ABLE MARINE ENERGY PARK (AMEP)

Planning Inspectorate Reference: TR030001

NATURAL ENGLAND'S RESPONSE TO COMMENTS ON THE RELEVANT REPRESENTATIONS

Figure 32.1 Foreshore topography and model boundaries at Cherry Cobb Sands

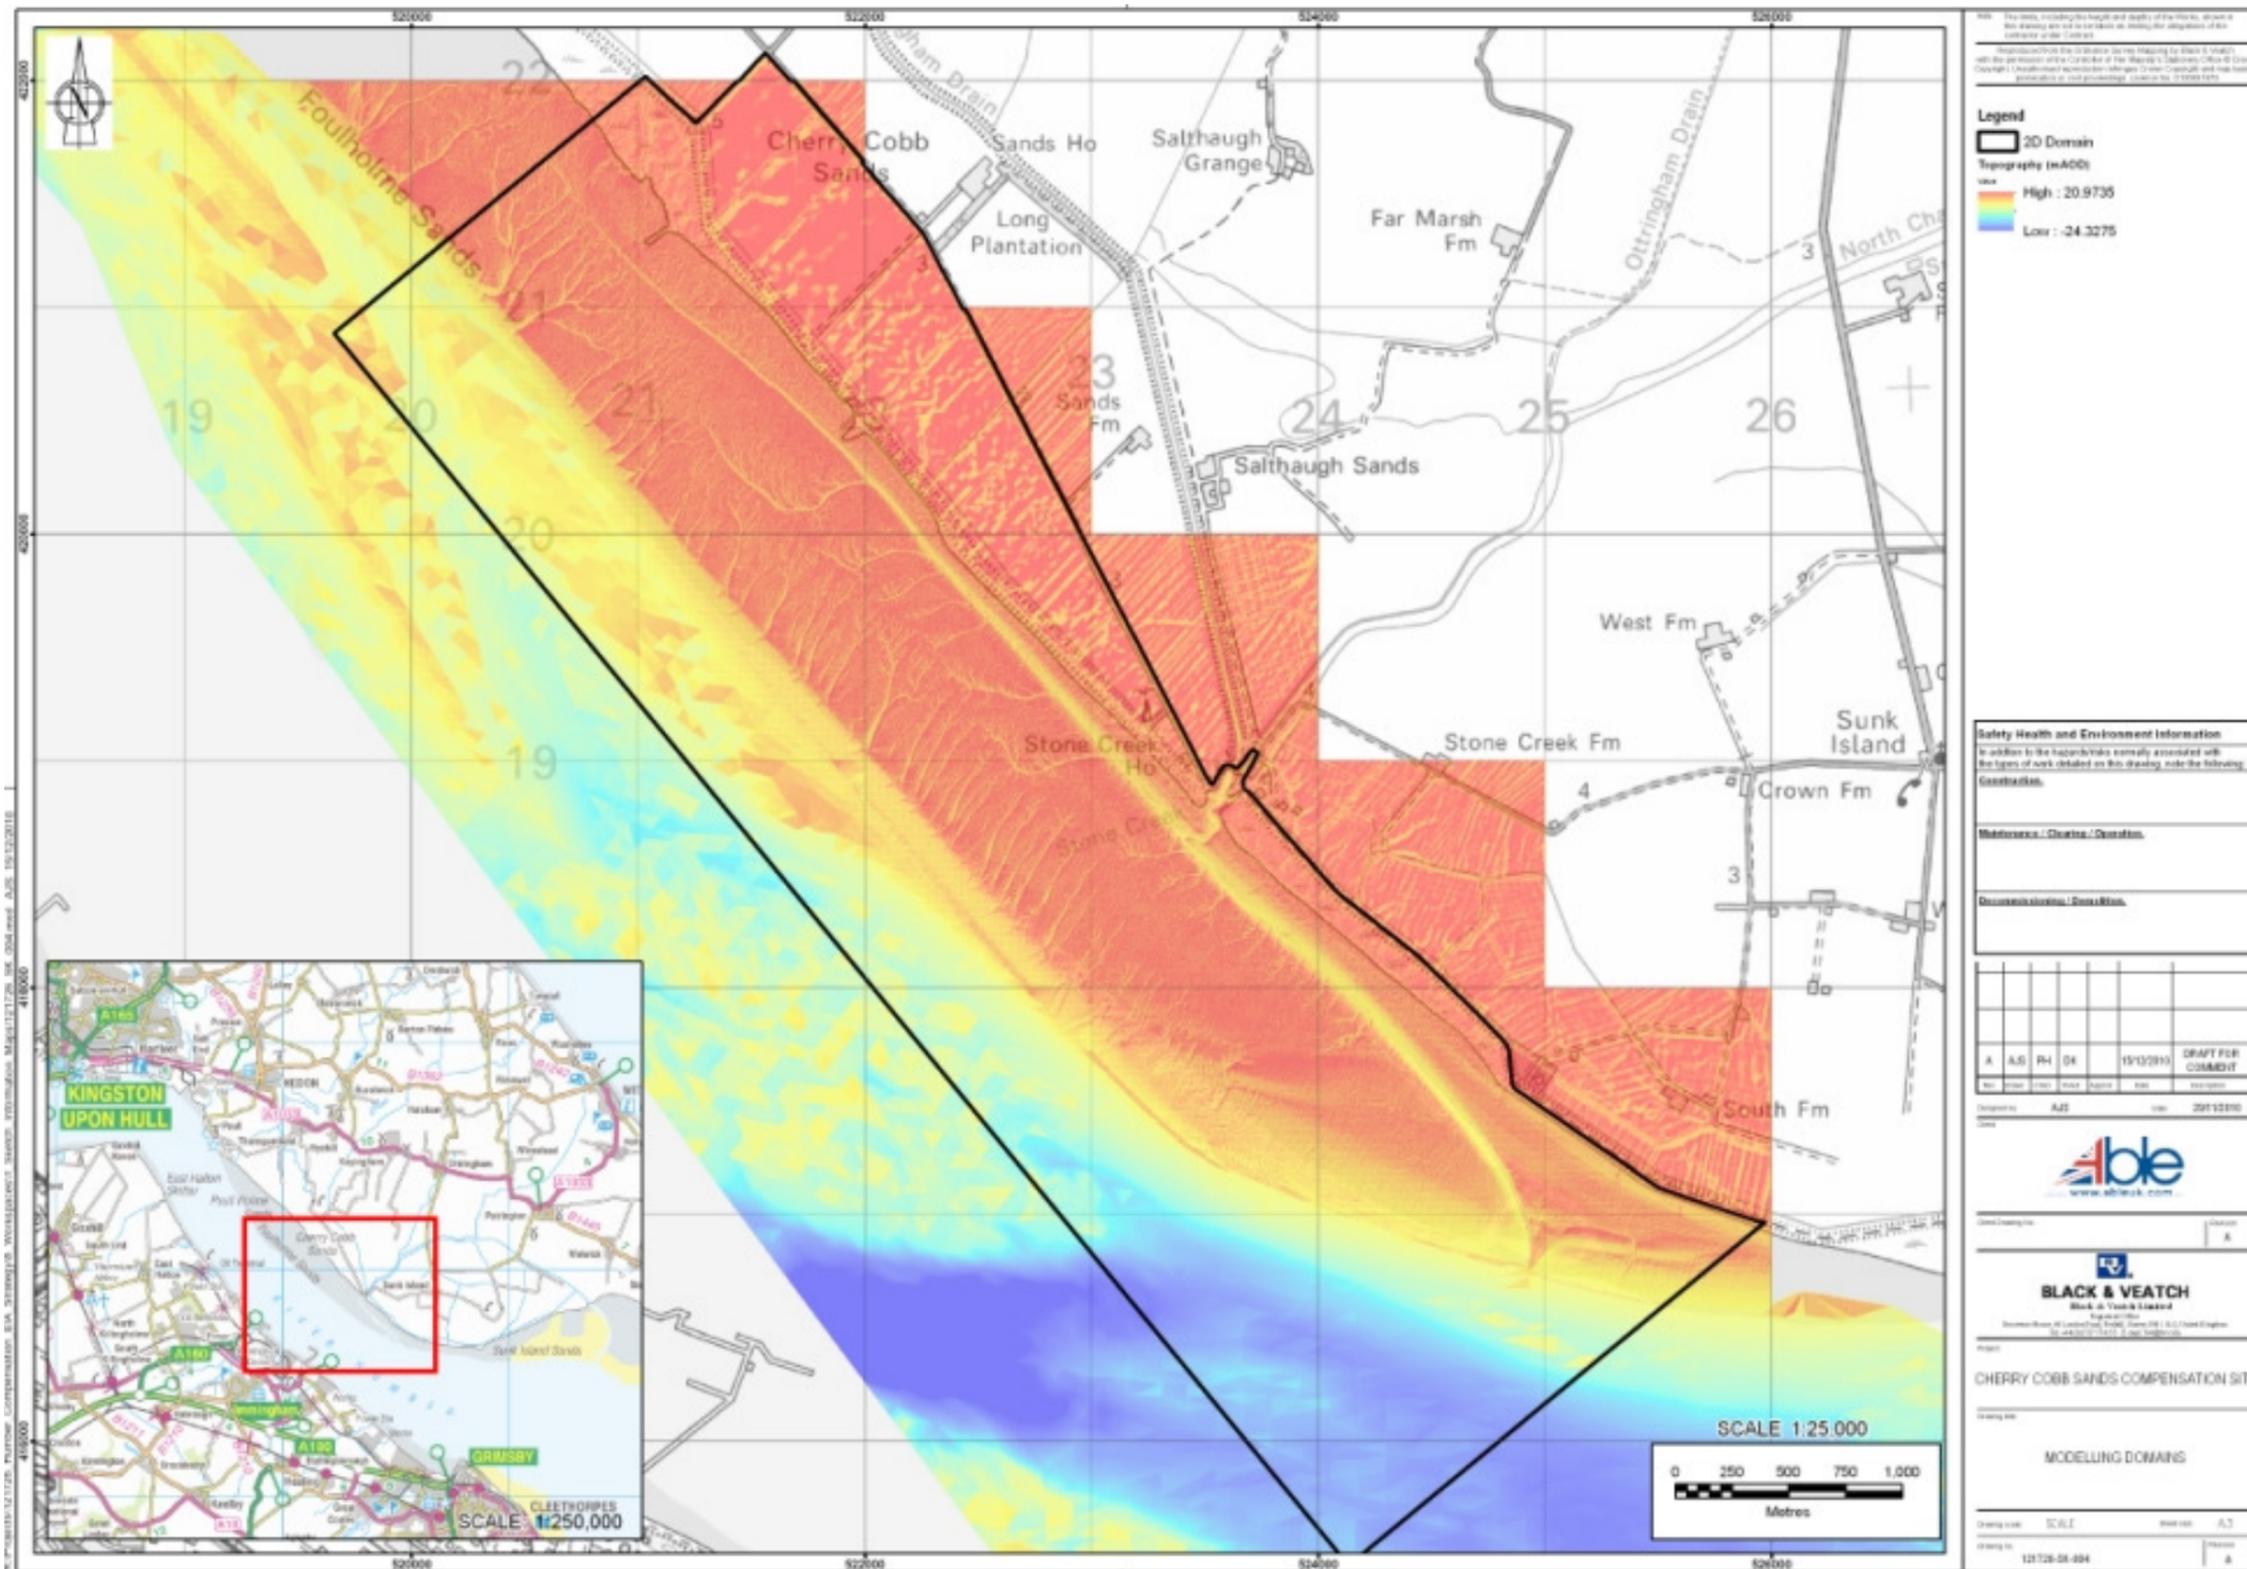
2.15.2 Natural England welcomes the supplementary work that has been included within report EX28.1 to try and gain an understanding of the design that will allow the

compensation site to meet its required targets. However the report shows that the compensation designs modelled to date do not provide sustainable mudflat over the long term.

2.15.3 The report discusses two different designs of the compensation site which have been modelled. The first predicts that there will be only 41ha of mudflat (from a starting figure of 97ha) after the five years. The second predicts there will be 43ha of mudflat (from a starting figure of 92ha) after the five years. In both cases the quantity of mudflat is expected to decline further as time progresses, and no quantified predictions after the five years have been provided. These modelled predictions do not provide 2:1 compensation or even 1:1 compensation over the medium or long term. It is also noted that there are uncertainties associated with the modelling of $\pm 20\%$.
